From: June Grinstead [REDACTED]
Sent: 11 May 2020 08:04
To: Zac Denton <Zac.Denton@arun.gov.uk>
Cc: Juan Baeza <Juan.Baeza@arun.gov.uk>
Subject: Re: LU/36/20/HH : 2 Etherington Place

Proposed Elevations

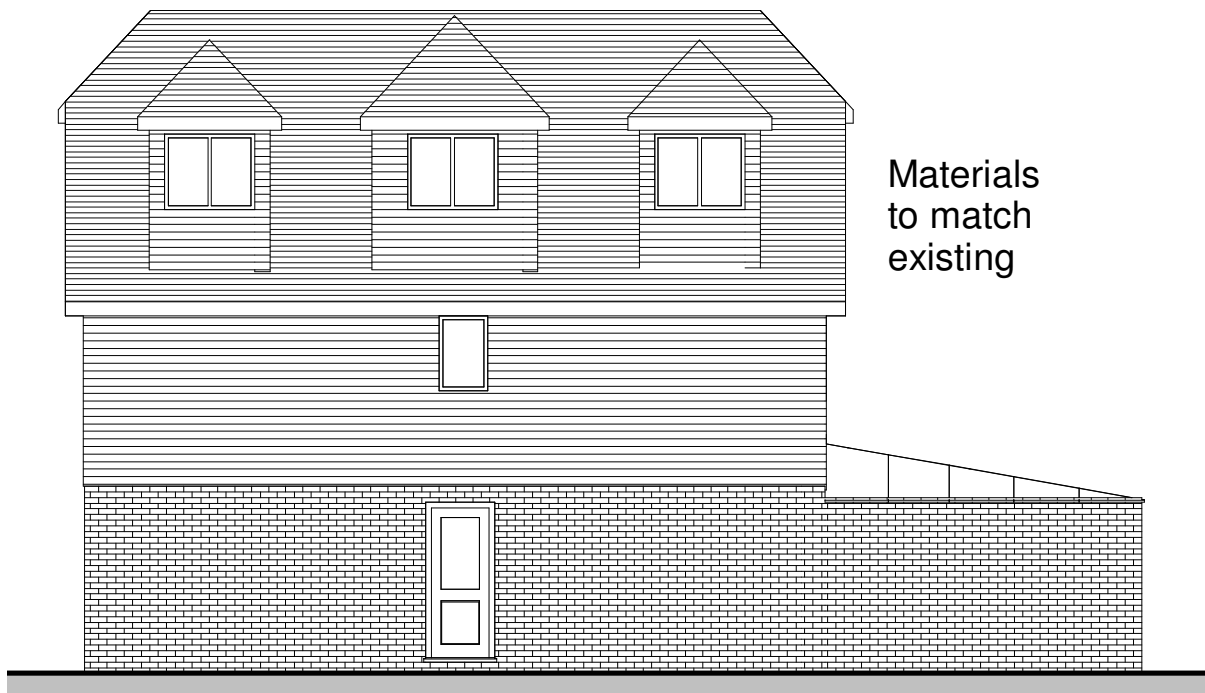
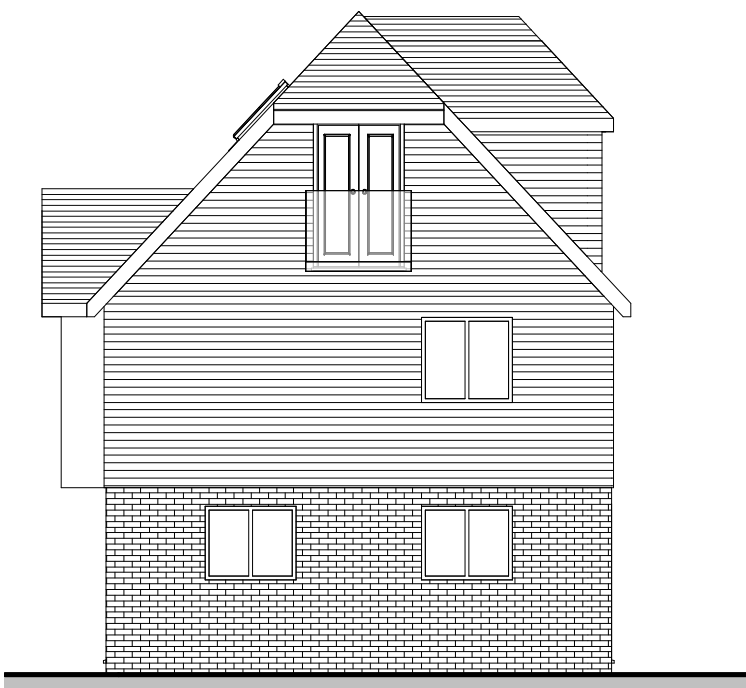
Are you able to confirm as to whether the elevations are labelled correctly? Apologies that this has come up reasonably late in the process.

Also, I am informing you that my Team Leader has concerns relating to potential for loss of privacy to adjacent occupiers, however, it could be considered that this can be mitigated via planning condition.

I've updated the Proposed Elevations and Loft Floor Plan to show the new window and that the rear bedroom window will be fixed close and obscure glazed. We don't want an extension of time for this window so it can go in as a minor amendment if necessary.

I apologise, I've updated the elevations to show the correct direction. I've also attached a section to show that the velux windows facing the side of the neighbouring property have a sill of 1.7m, Bedroom 5 only faces the side of the property to the South and the French doors face a field. The only other issue is Bedroom 6, that could have a view over the garden to the South, can we add a window in the gable end facing a car park?
